13 December 2019

BLP - Responses to SSDA Submissions

**LIBRARY WETLANDS
CENTRE**

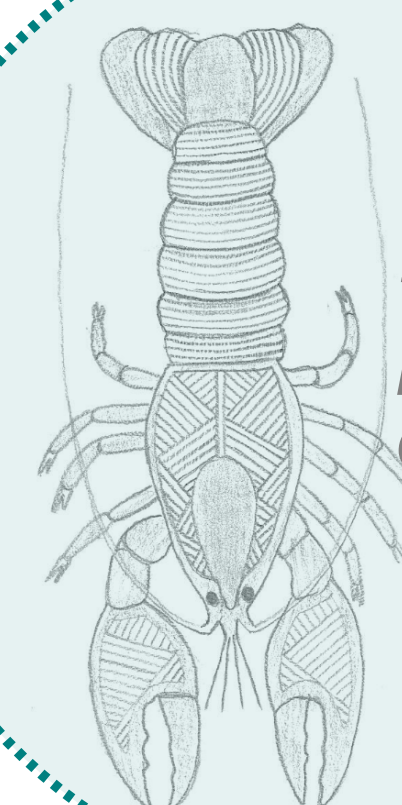
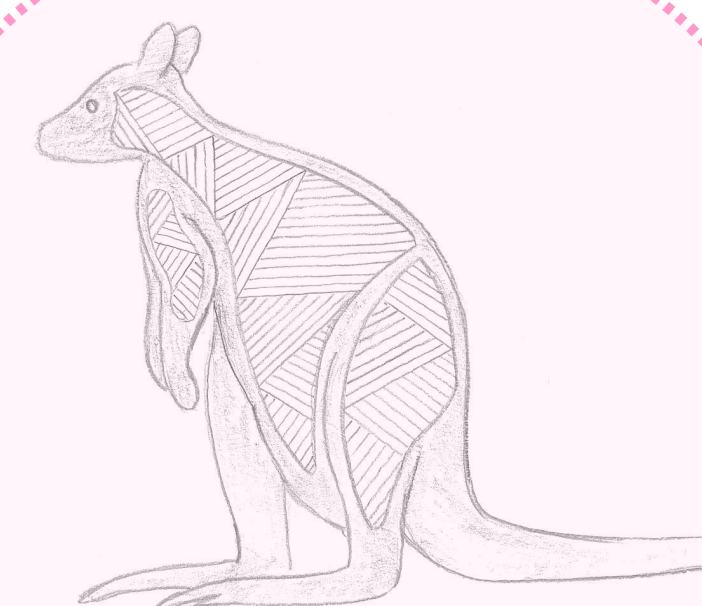
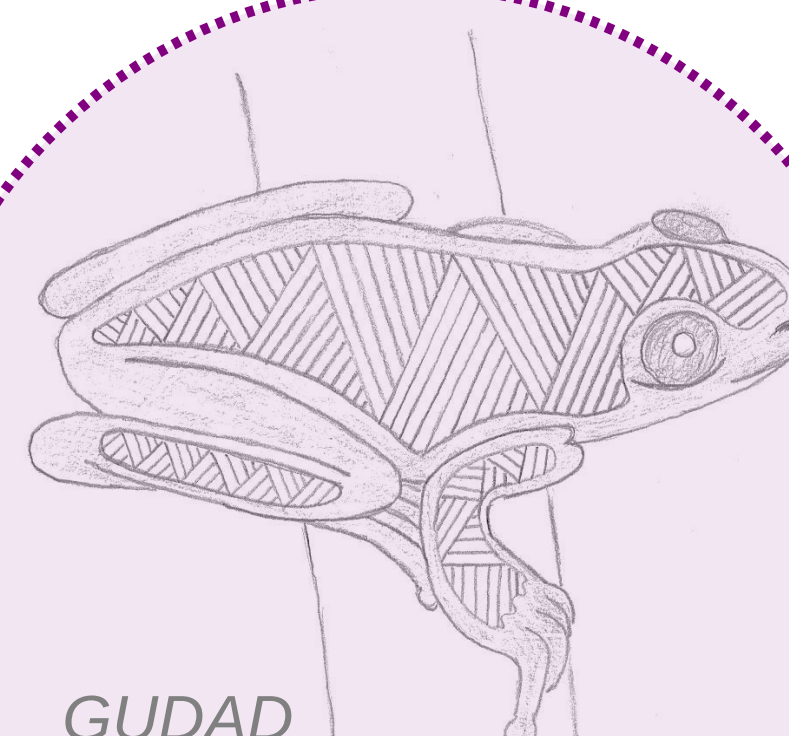
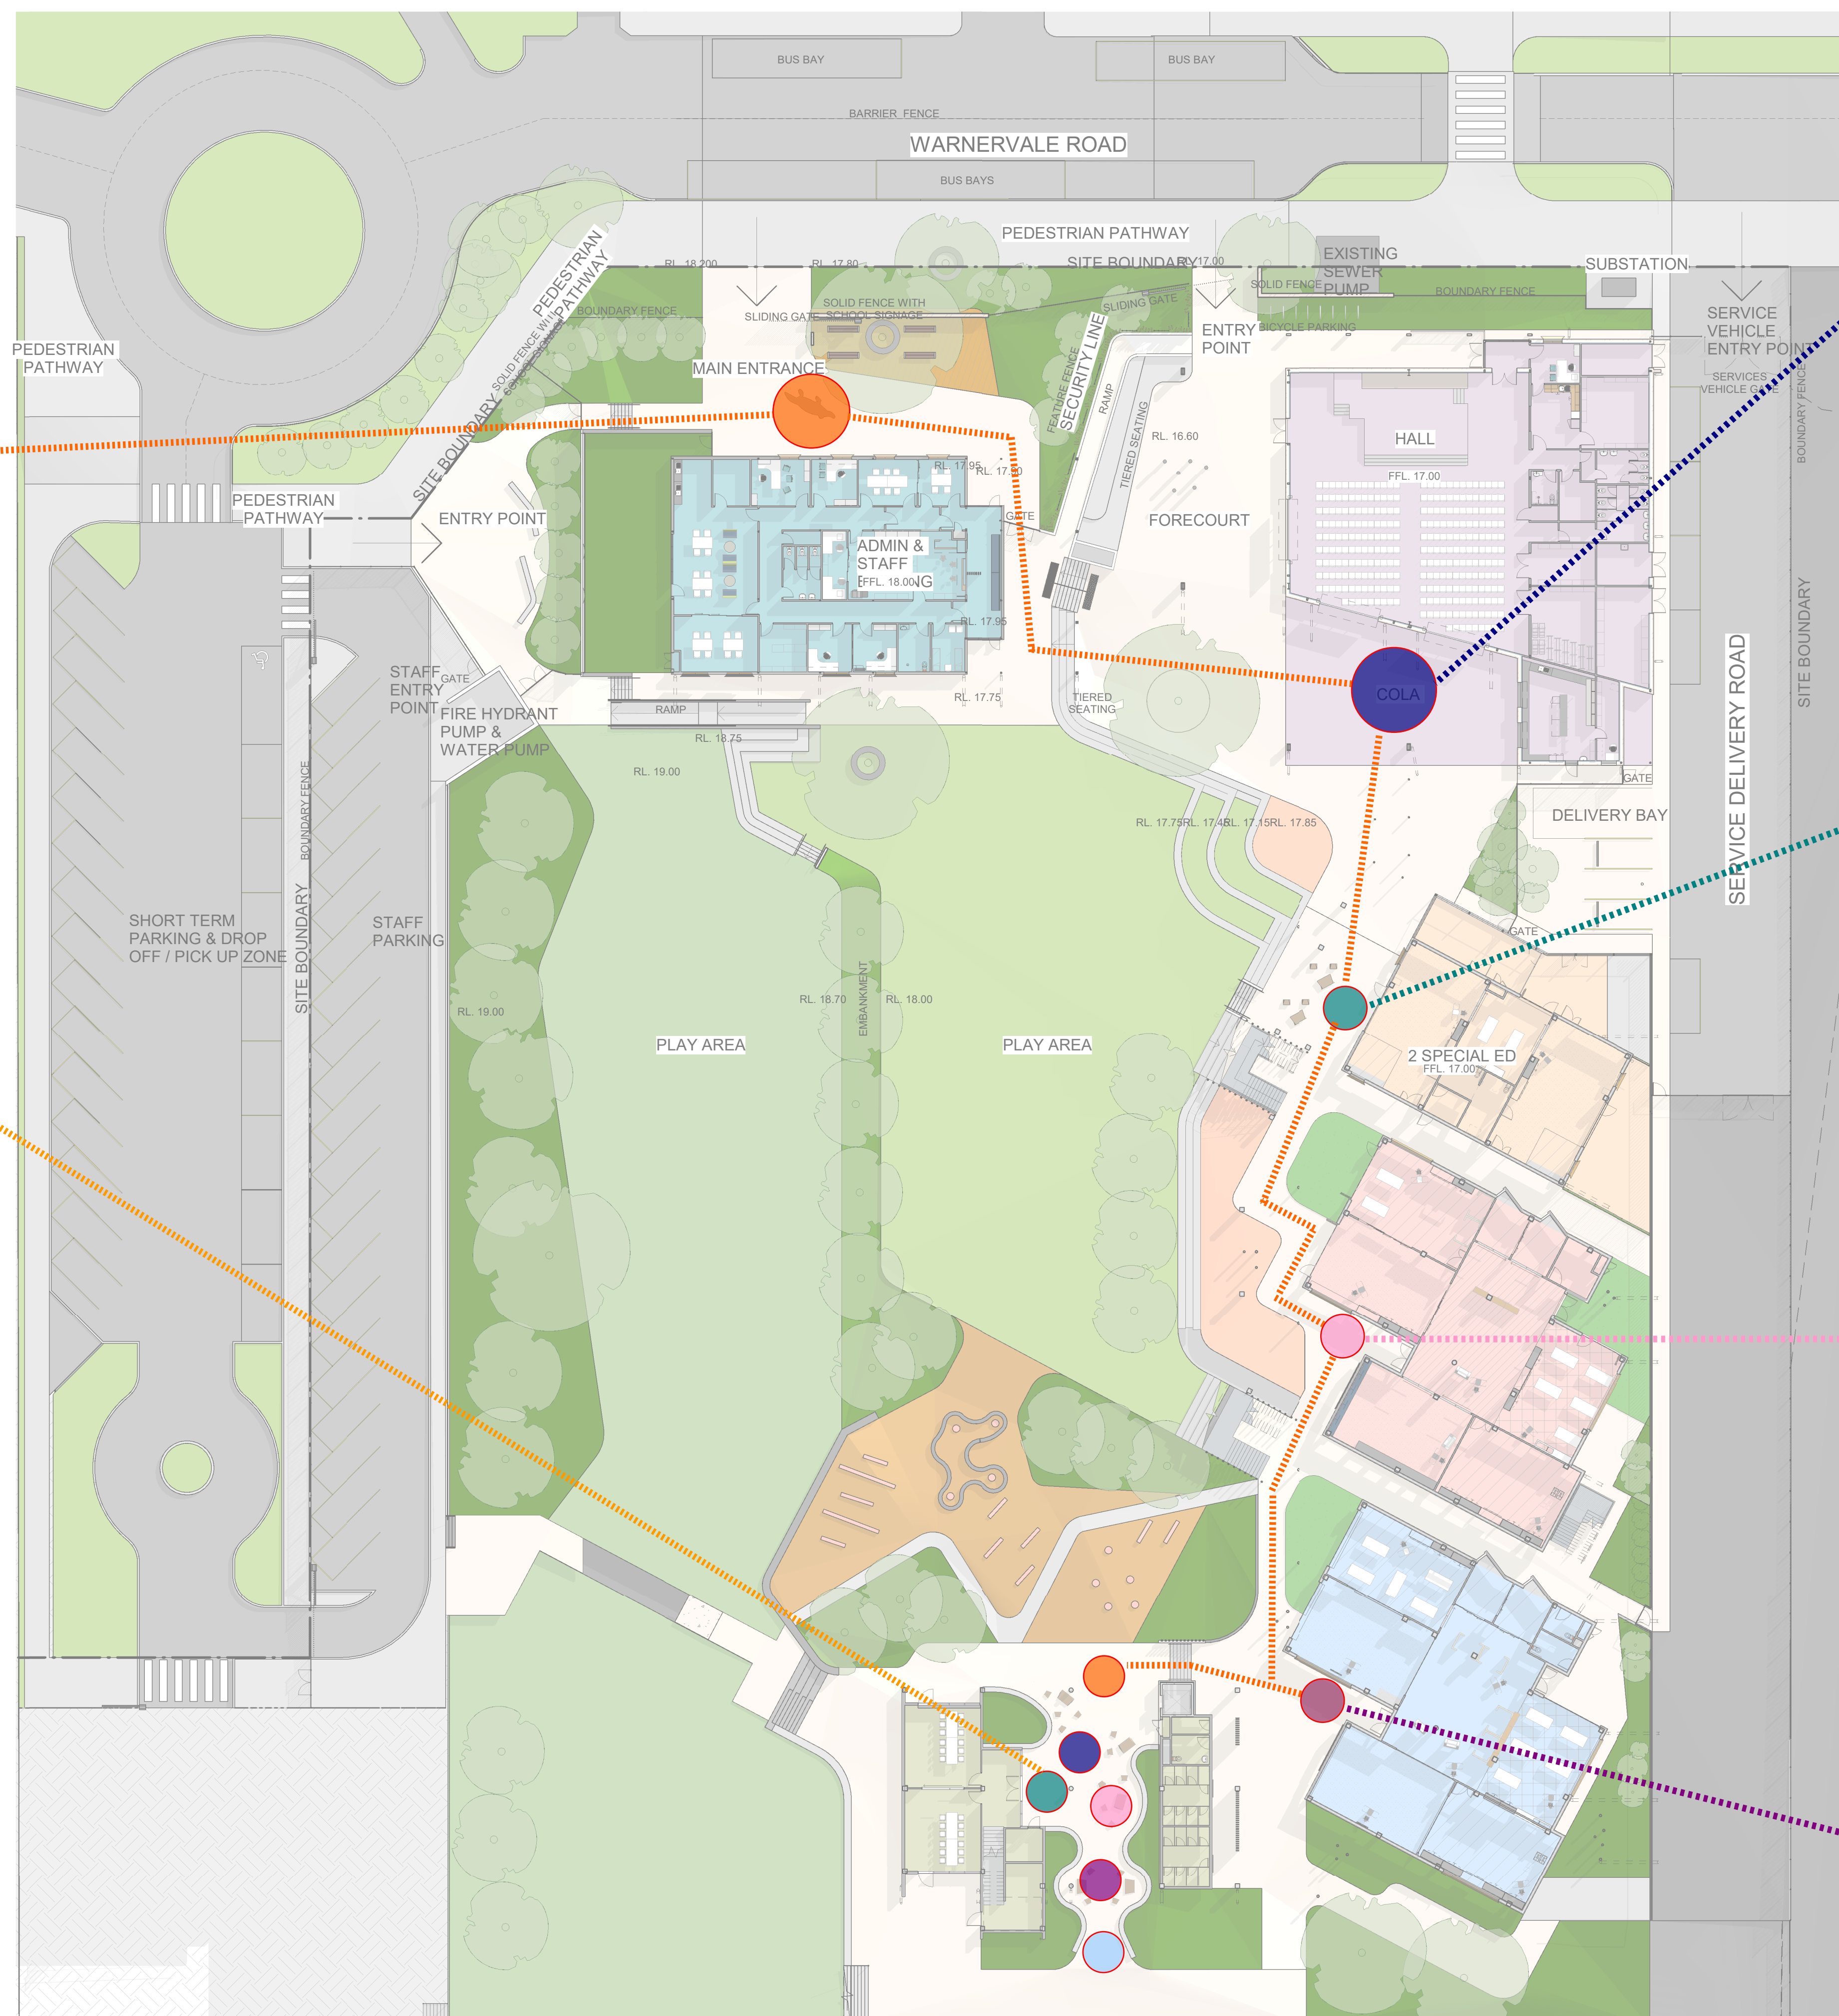
Item	BLP Response
Government Architect Comment: <i>Further use of the Aboriginal consultation through using place naming and planting of local species to educate the students about the Aboriginal heritage of the site.</i>	<p>Agree. Consultation with a Local Aboriginal Representative has been undertaken and will be ongoing throughout the duration of the project.</p> <p>Refer to Indigenous Species Graphics and Signage Package for further details about the proposed integration of the local species.</p>
Central Coast Council Comment: <i>A north-south tree canopy corridor (preferably eastern side) is to be provided through the site to link with the vegetation and oval on the northern side of Warnervale Road. The corridor is to include native trees whose canopy provides a linkage for fauna through the site to Warnervale Road and should include replacement street tree planting with a large canopy to allow for a squirrel glider link between the tree canopies and vegetation located on either side of Warnervale Road. This corridor currently exists on site and needs to be retained to minimise potential for the existing squirrel glider population to be adversely impacted by the proposal.</i>	<p>BLP and Kleinfelder have prepared a proposed canopy corridor to address this comment.</p> <p>Refer to Squirrel Glider Canopy Link Diagram.</p>
